Report of the Head of Planning and Development**STRATEGIC PLANNING COMMITTEE****Date: 15-Jul-2020****Subject: Planning Application 2020/90584 Erection of extensions, rear dormers and external alterations 56, St Paul's Road, Mirfield, WF14 8AY****APPLICANT**

FRONT

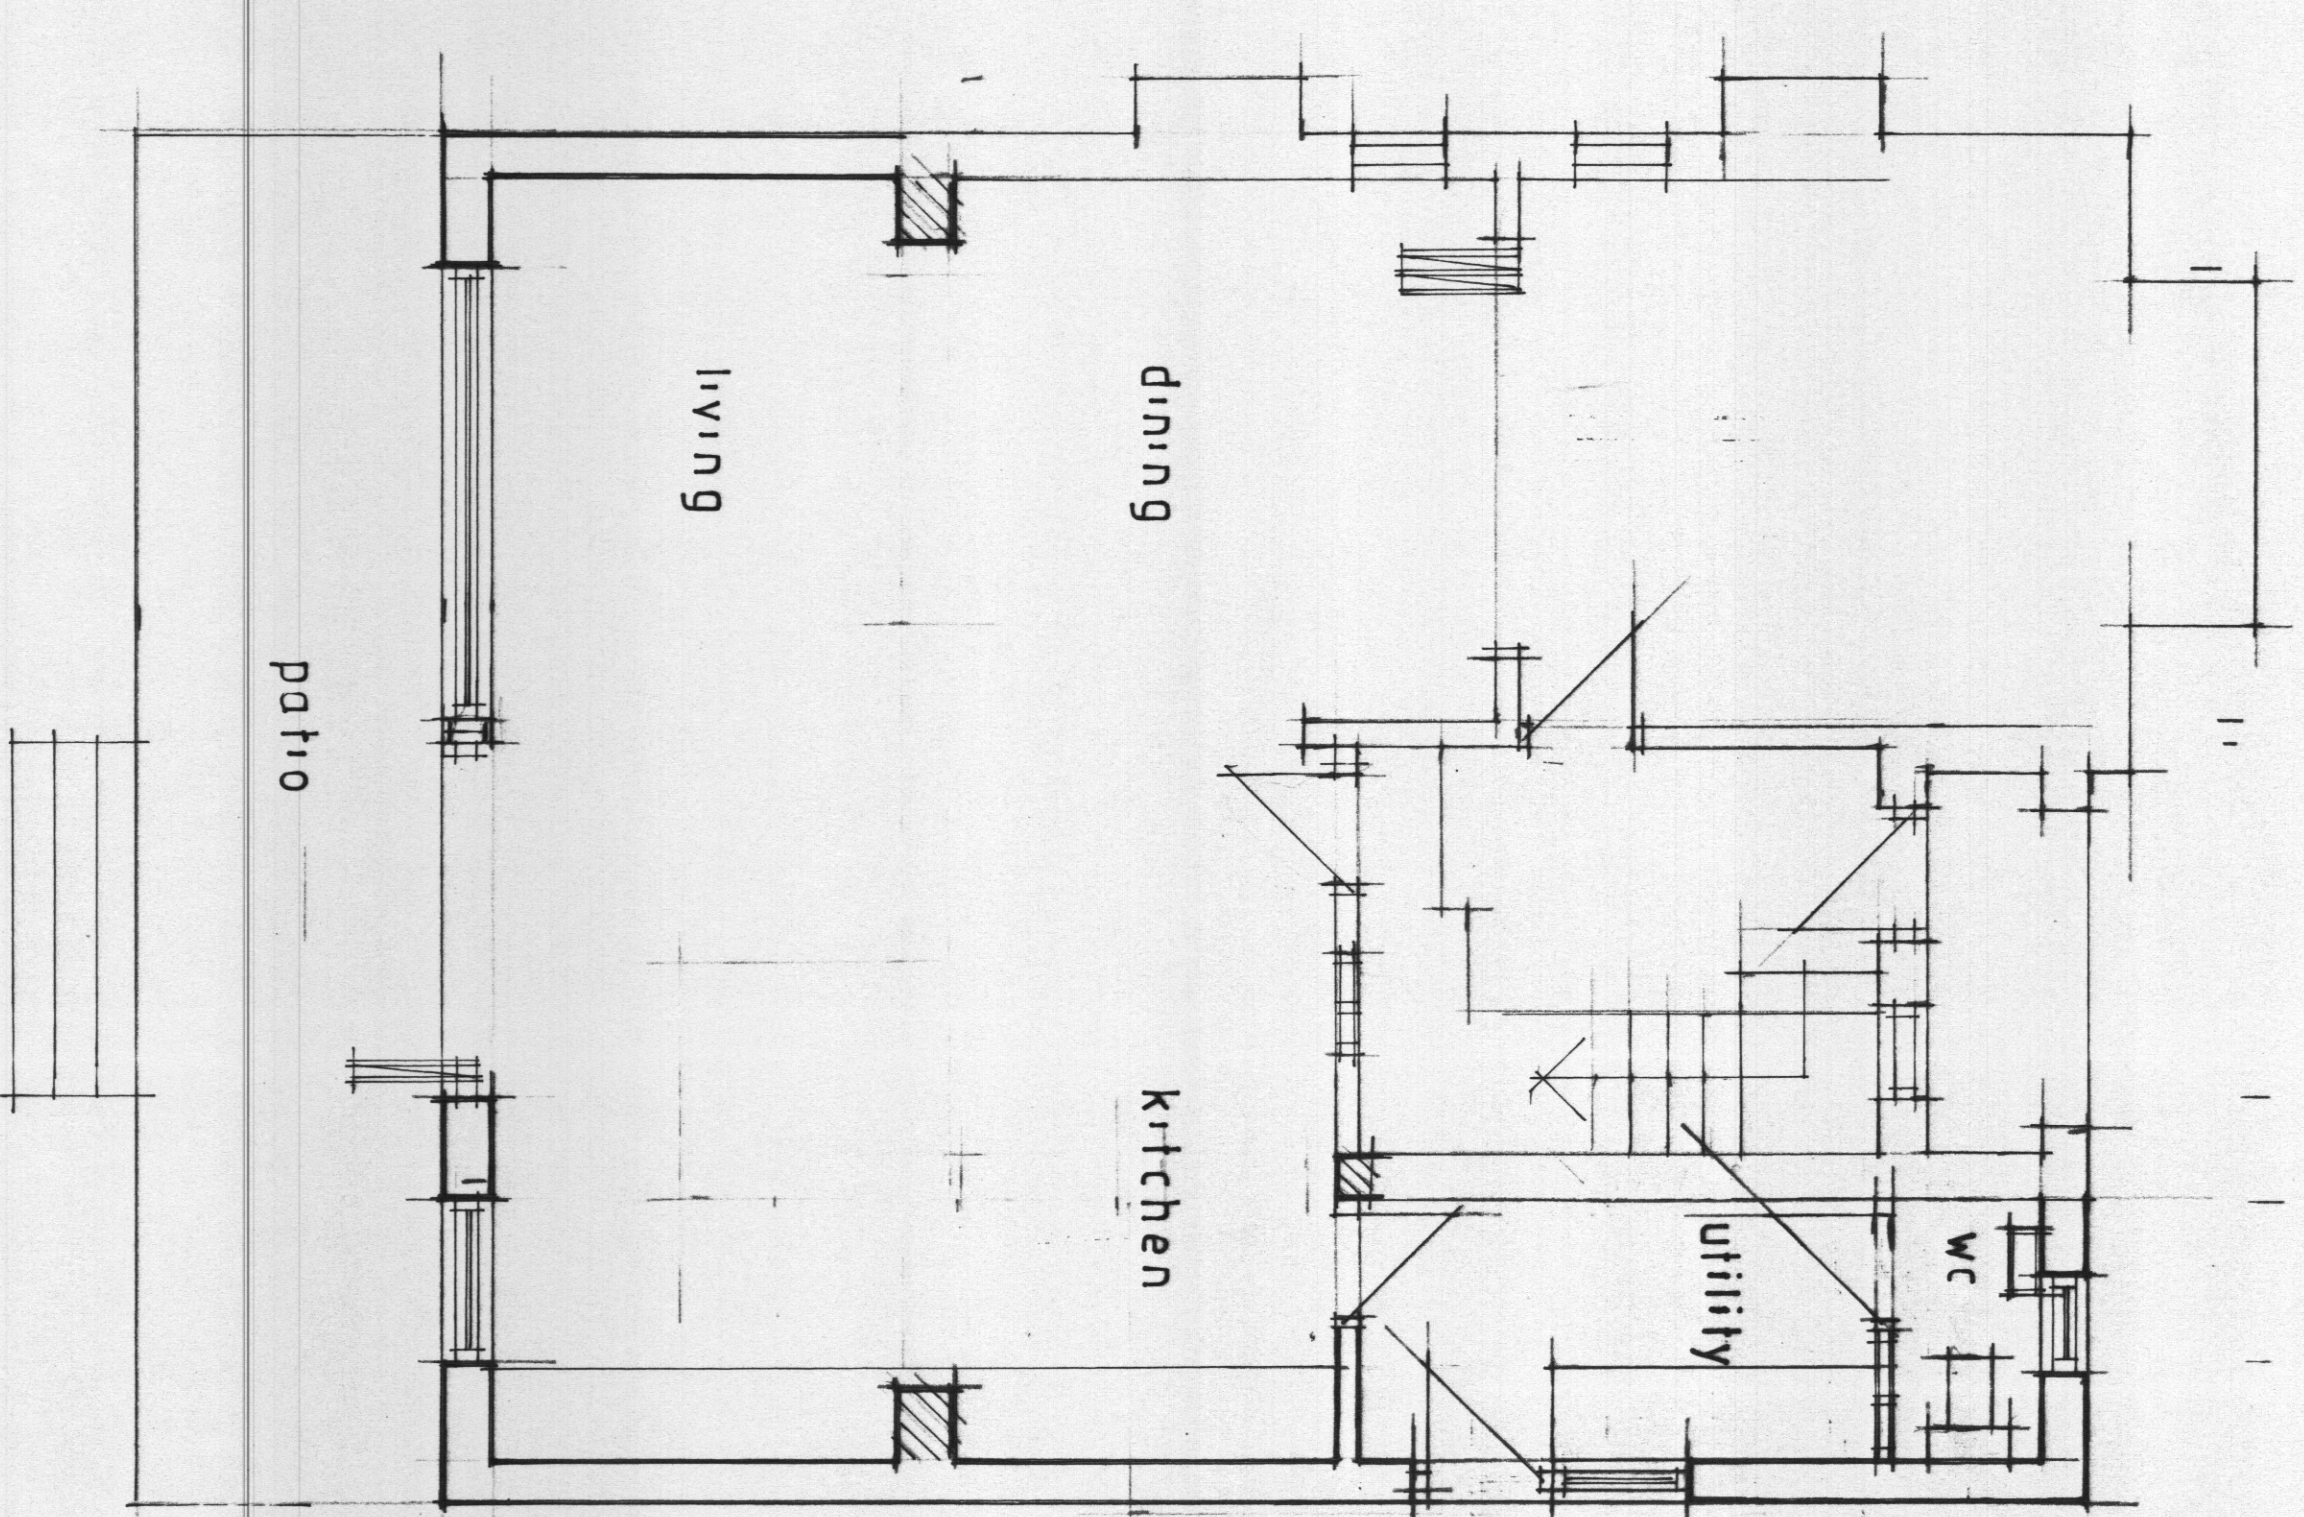
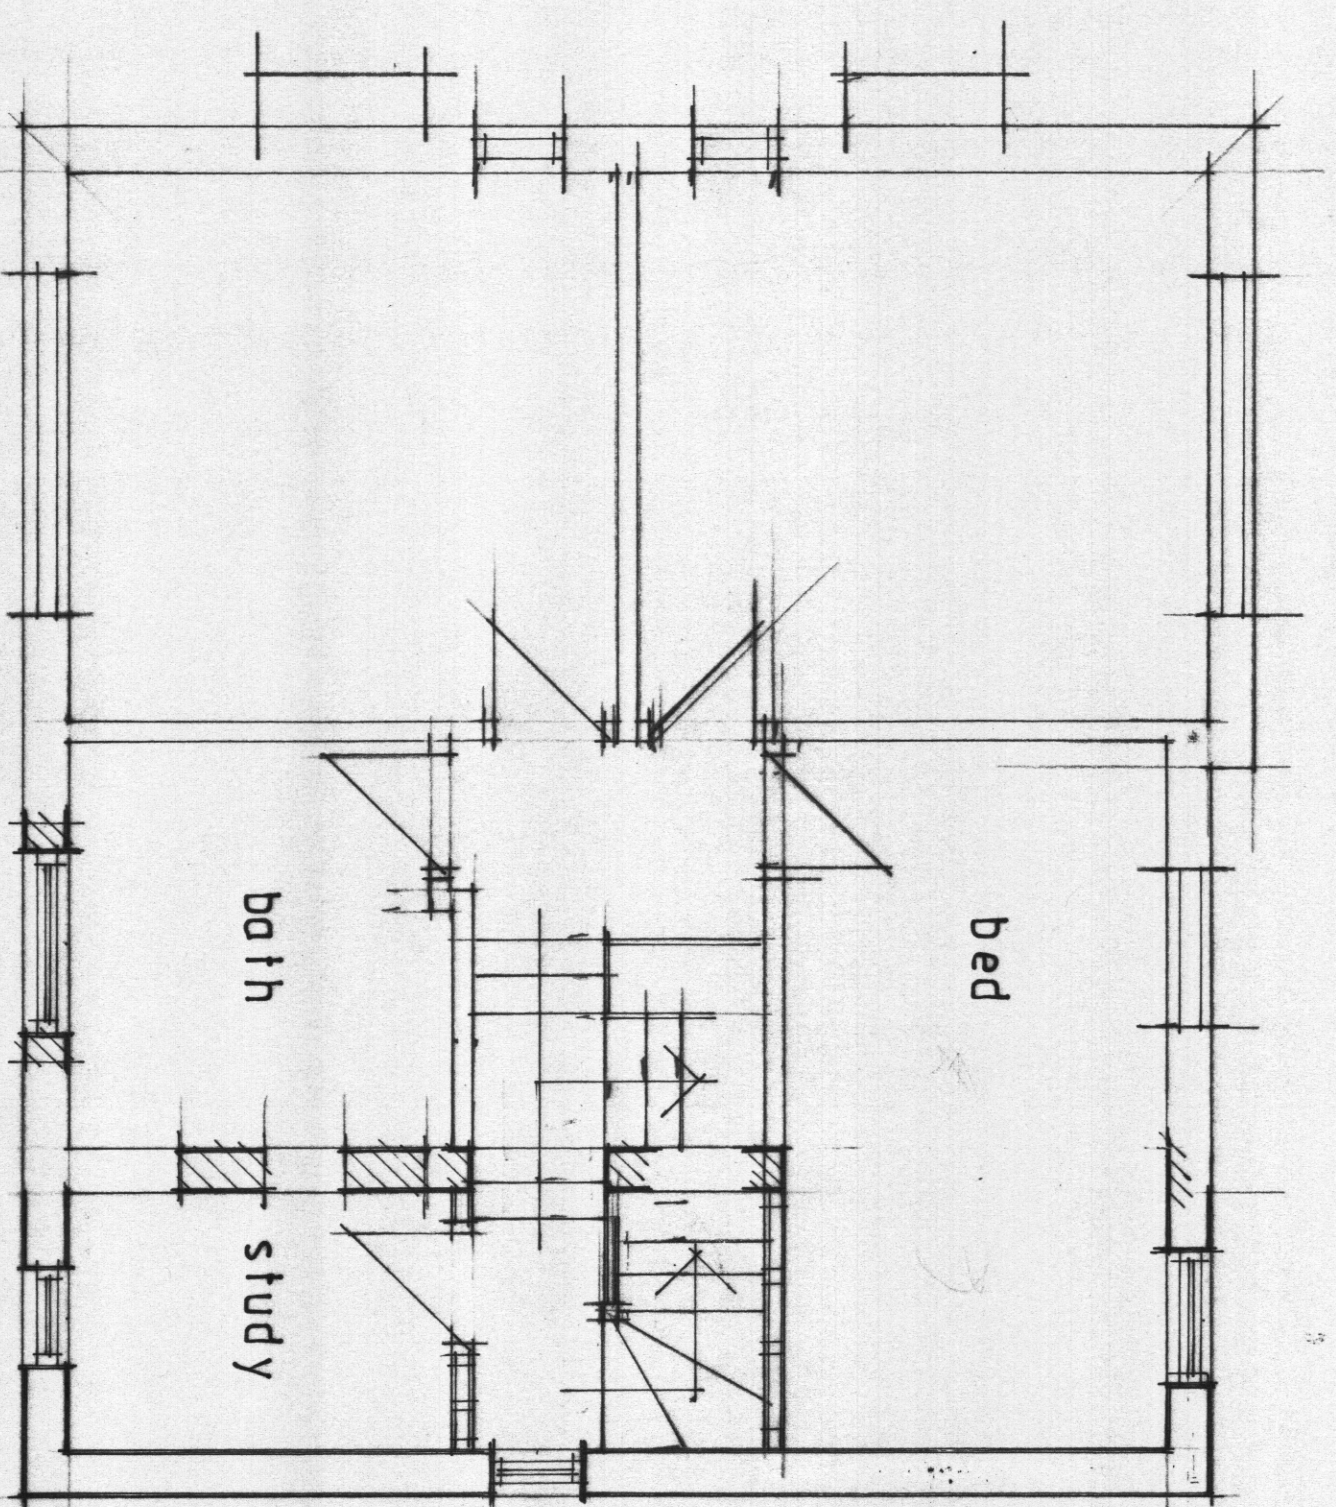
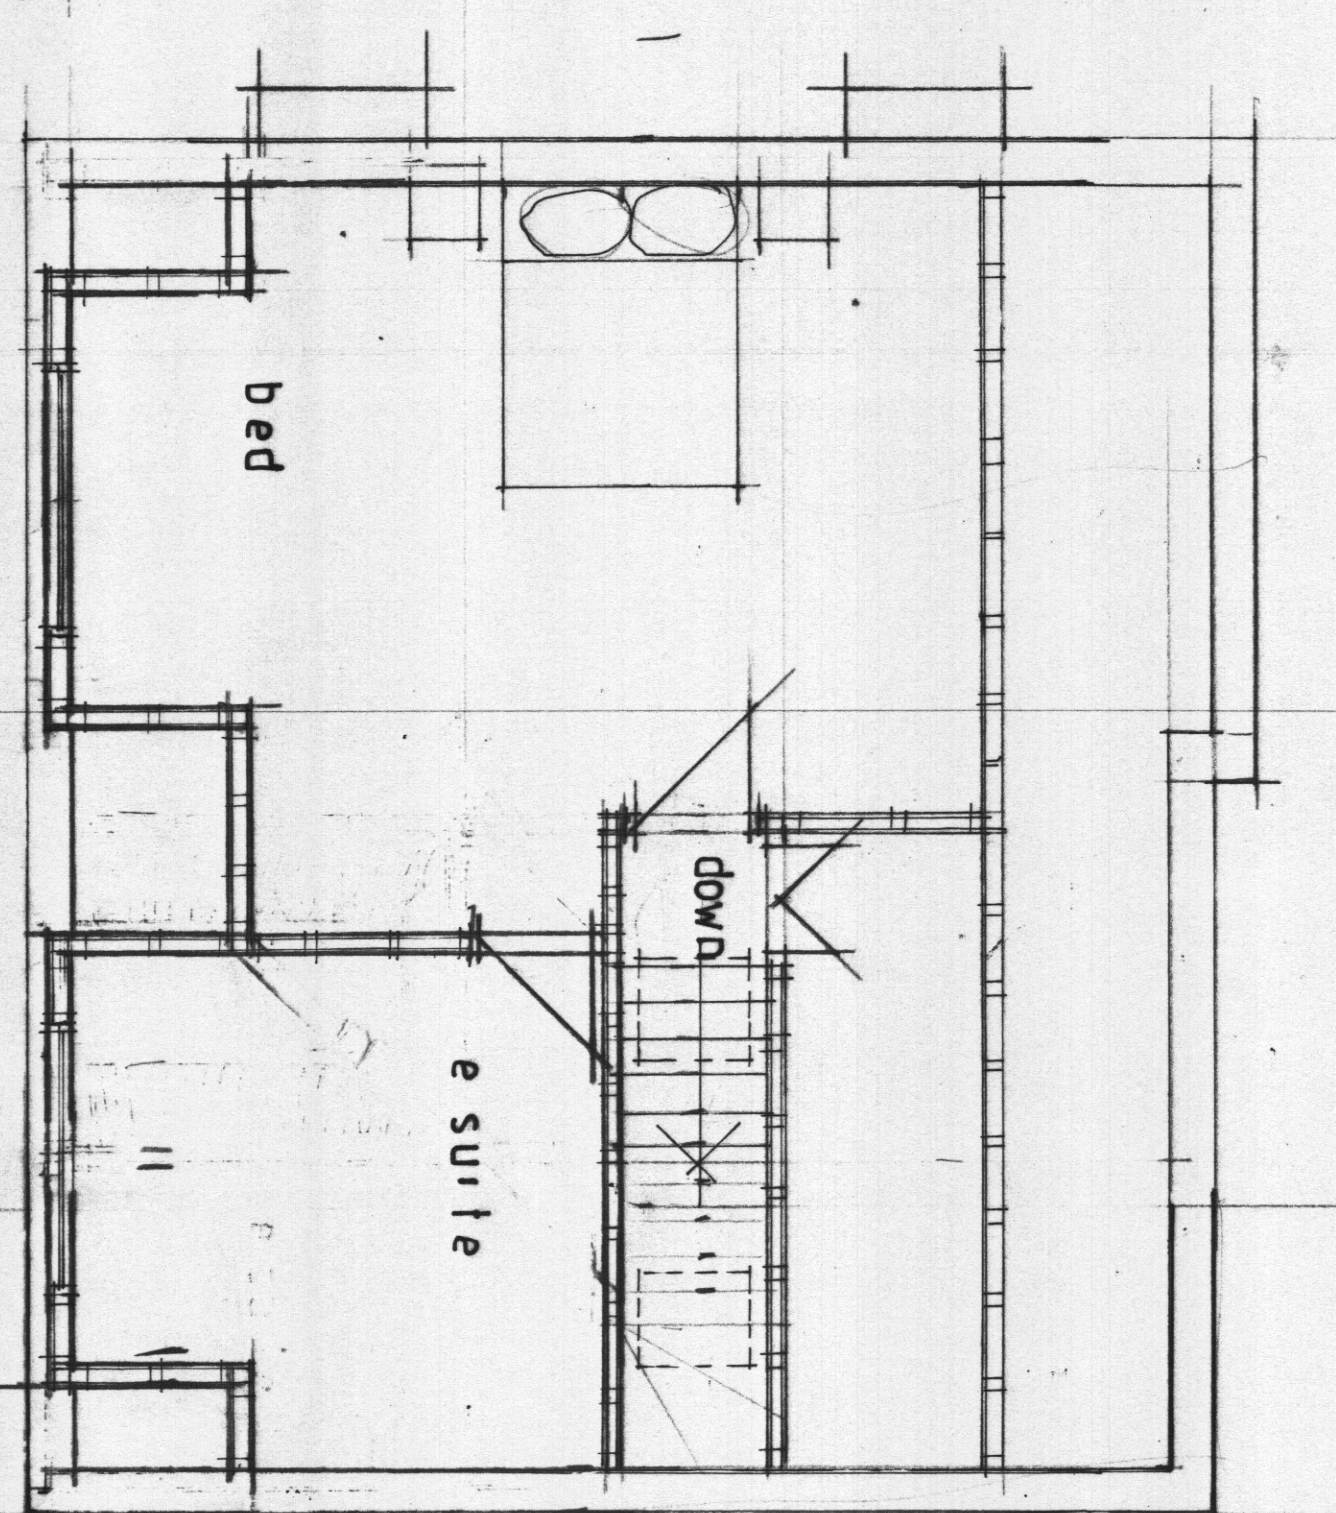
- 5.1 The design of the flat roof dormer has been amended in order to reduce its prominence when looking from the southern aspect of the application property. The facing material of the single storey rear extension has also been amended to ensure that a satisfactory relationship would be established with the host property. The amended drawing was received on 14-Apr-2020.

- 10.3 As to the dormers and external alterations, they would fundamentally change the roof of the application property from a hipped roof to a gable roof with its ridge in line with that of the adjoining properties on St Paul's Road. Two dual pitched roof dormers would be erected to the gable roof serving an en-suite bedroom on the second floor. These elements of the proposal would have an impact on the visual appearance of this property.

- 10.5 All extensions alongside the existing building would be faced with cream coloured render. This again would give rise to a noticeable impact on visual amenity. Notwithstanding this consideration, officers do not find the use of coloured render to unduly detract from the appearance of the host property and those surrounding it. The buildings nearby are all constructed in different materials including brick, stone and render. This contributes to the diverse street scene of St Paul's Road. Furthermore, the property immediately adjacent to the site at no.58 appears to be faced entirely with white coloured render. Under these circumstances, the proposed coloured render is considered appropriate in terms of visual amenity. The roofing materials of all extensions are to match those used in the construction the host building. The dormers would be faced with grey coloured cladding to match the roof tiles. In summary, the materials of construction as proposed would be satisfactory in respect of policy LP24 of the KLP. To ensure a satisfactory appearance of development is achieved, a condition is recommended to require the application property be faced with cream coloured render and retained thereafter.

- 10.10 According to the proposed elevations drawing, there would be no windows in the side elevation facing no.54. No privacy issues would arise from this development. In the interest of residential amenity, a condition is recommended to withdraw permitted development rights for insertion of new openings in the south-western aspect of the single storey rear extension. Subject to this condition, the living conditions of these neighbours would not be unduly prejudiced by the proposals.

1. Timeframe of 3 years for implementing the development
2. In accordance with the submitted plans
3. No openings in the South West and North East (side) elevations of the rear extension
4. External walls of the application property shall be faced in cream coloured render
5. Two off street parking spaces be provided in accordance with the approved block plan before the extensions are occupied
